DEPARTMENT OF PUBLIC WORKS

MEMORANDUM

TO: Jeff Watson, Community Development Services
FROM: Christina Wollman, Planner II *CW*
DATE: June 1, 2010
SUBJECT: Tomich SG-10-00010

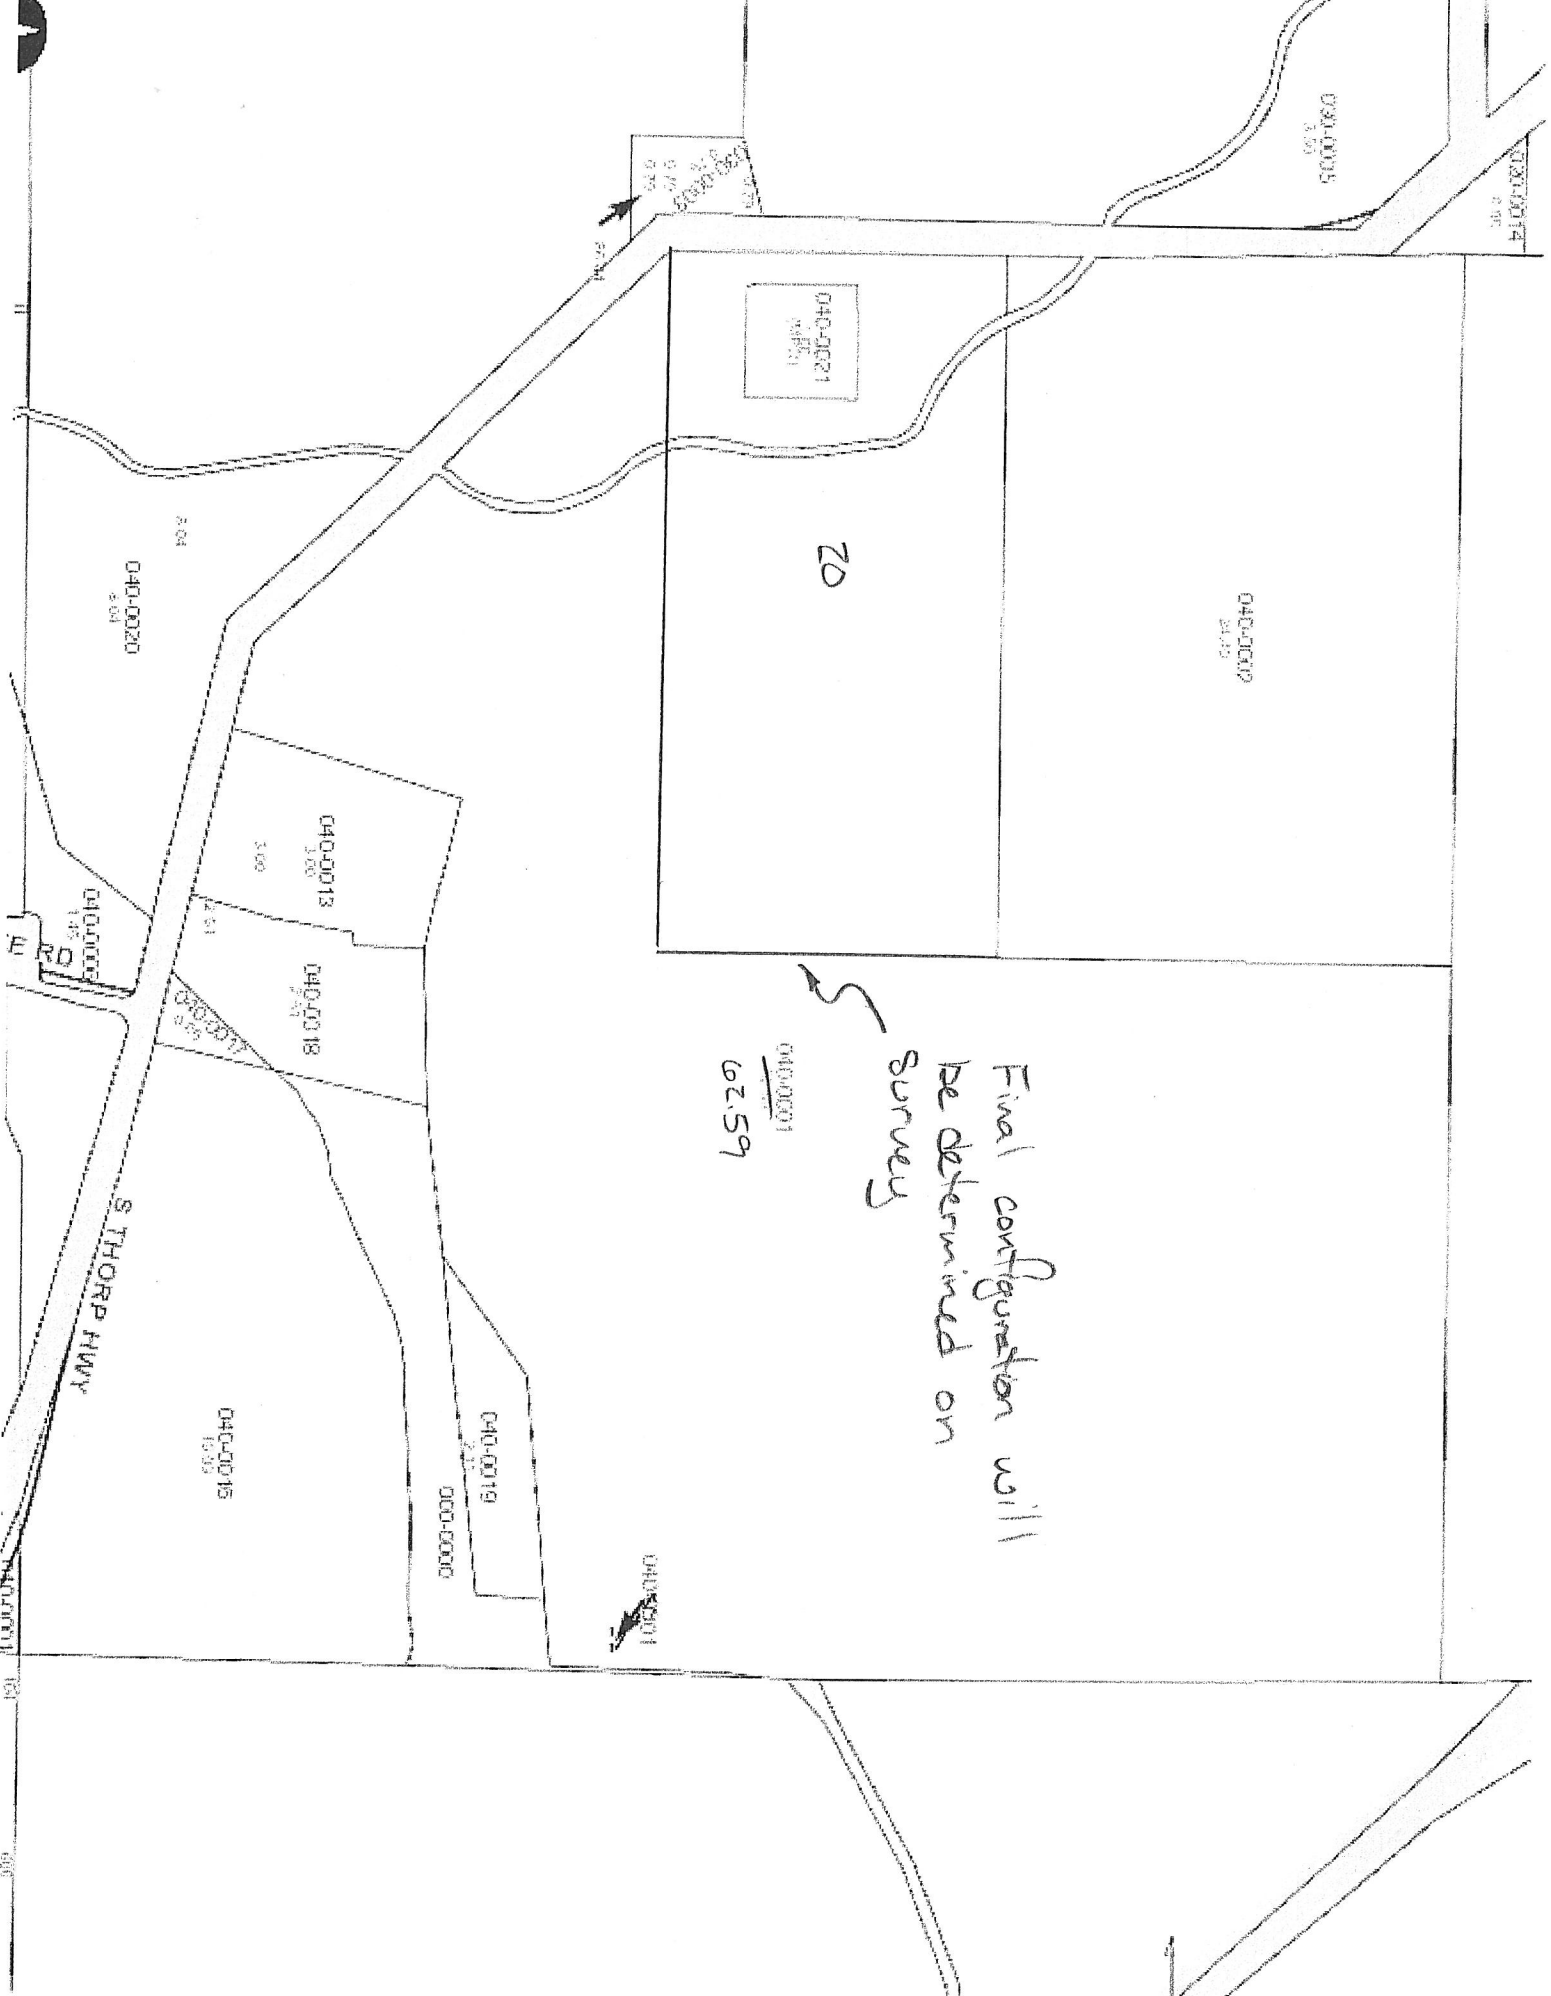
1. The proposed access with appropriate easement(s) shall be shown and shall conform to applicable Kittitas County Road Standards. Access locations should be determined prior to final approval to avoid future conflicts.
2. A survey describing the final configuration of the subject property shall be required.
